**ADC Planning Consultation
Response from the Historic Buildings Adviser**

Application Number	LU/307/14/L
Address	12 River Road, Littlehampton, BN17 5BN
Description	Application for Listed Building Consent for refurbishment works to out- building to create hobby room & include internal works.
Case Officer	Anita Gardner
Site Visit	Previous

No Objection subject to amendment

SECTION A-A 1:50

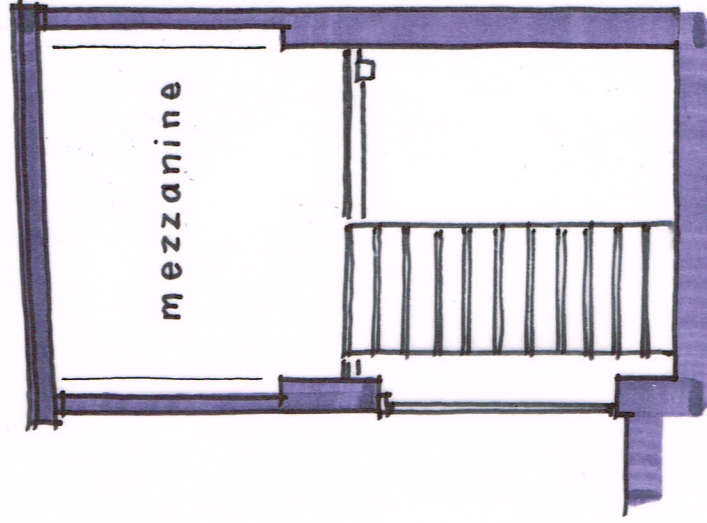
- Section showing structural support for mezzanine
- Staircase details
